Our Ref: PAY/WG/51836

Re: 12 River Road – Internal Alterations

51836 / SK01
Dixon Hurst Mark Up
June 17.

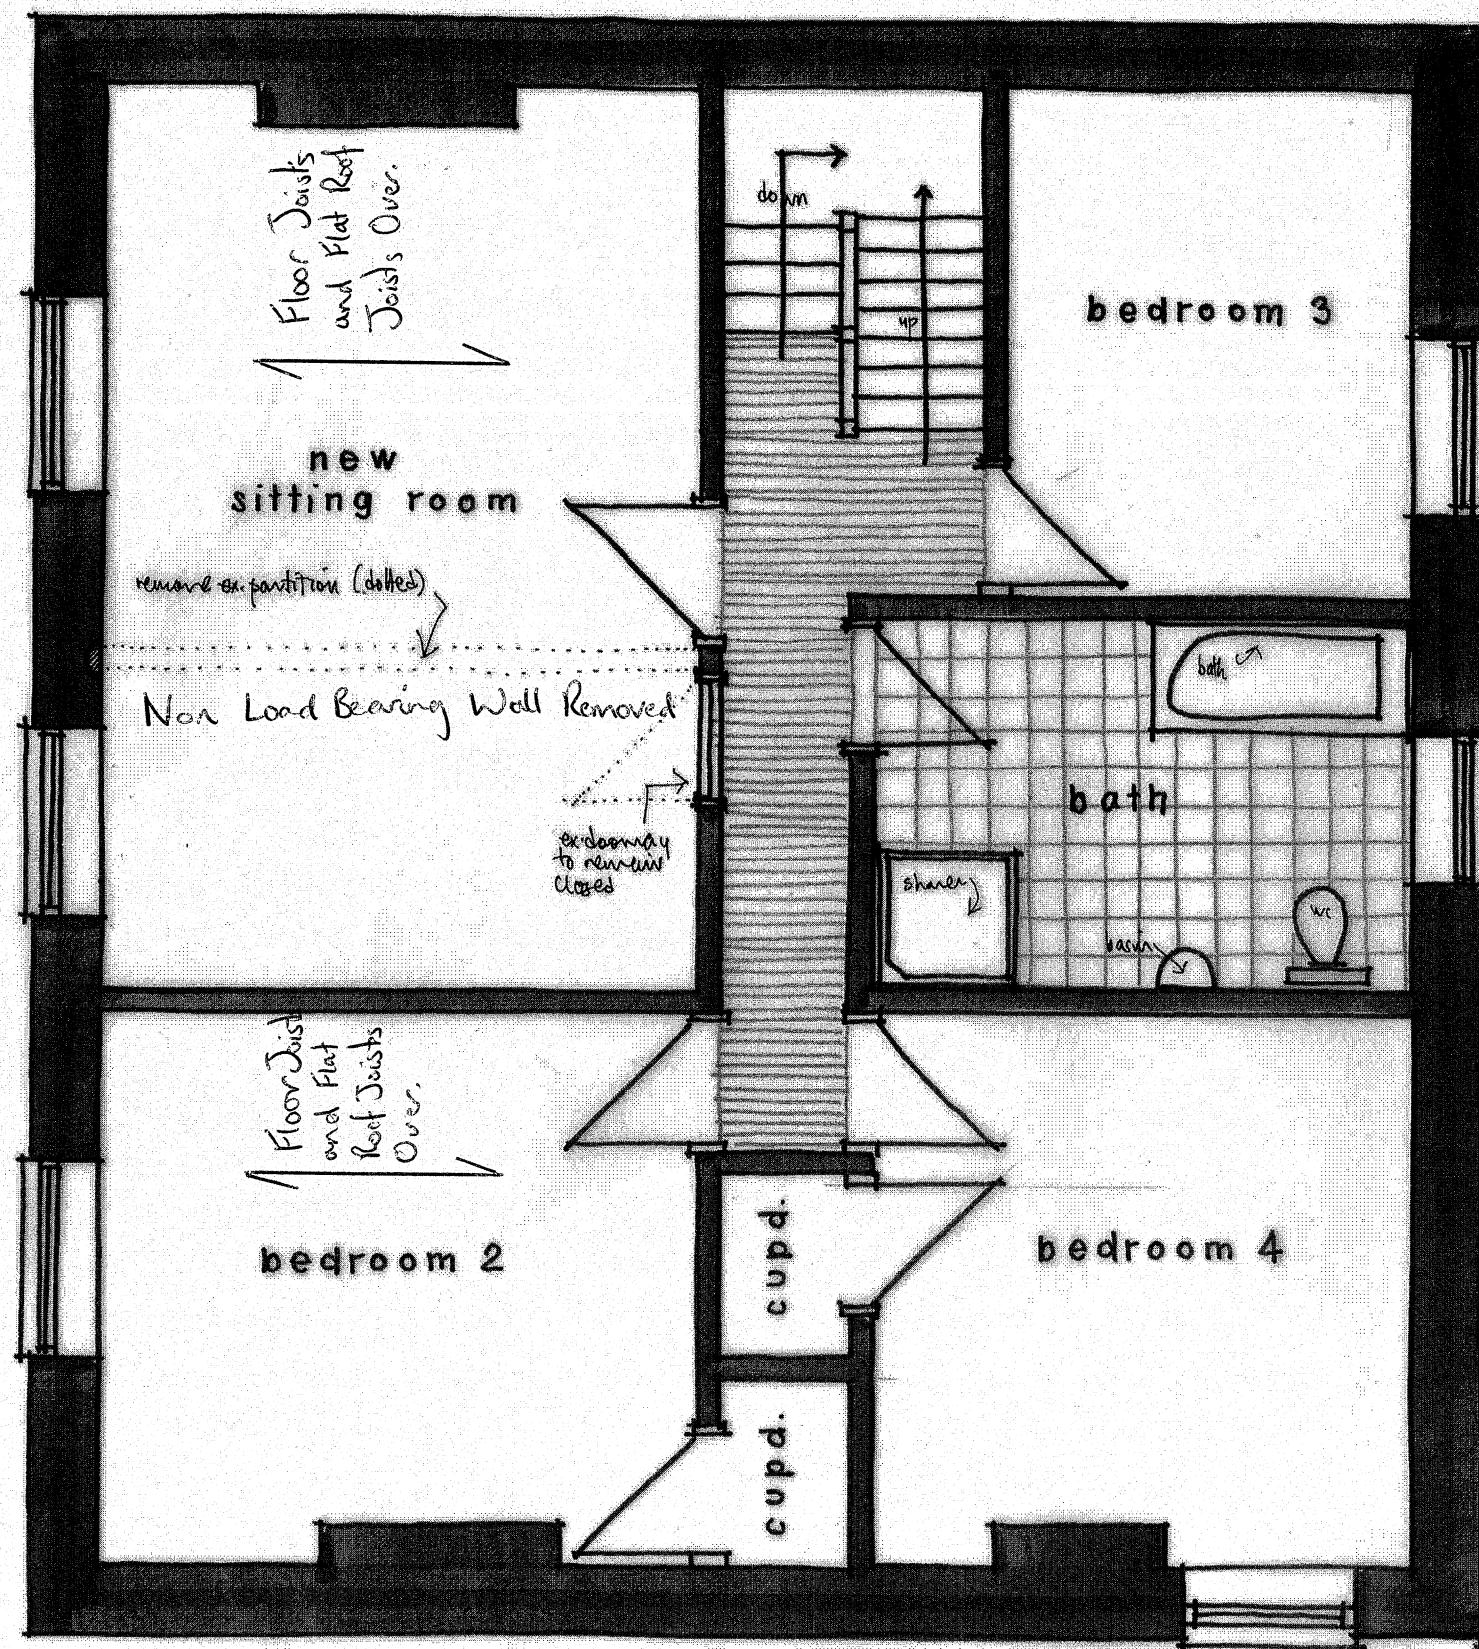
Further to our visit to the above property, we confirm the internal wall between the lounge and 3rd bedroom as indicated on our drawing number 51836/SK01 enclosed, is non-loadbearing and can be safely removed without the need for any additional structure.
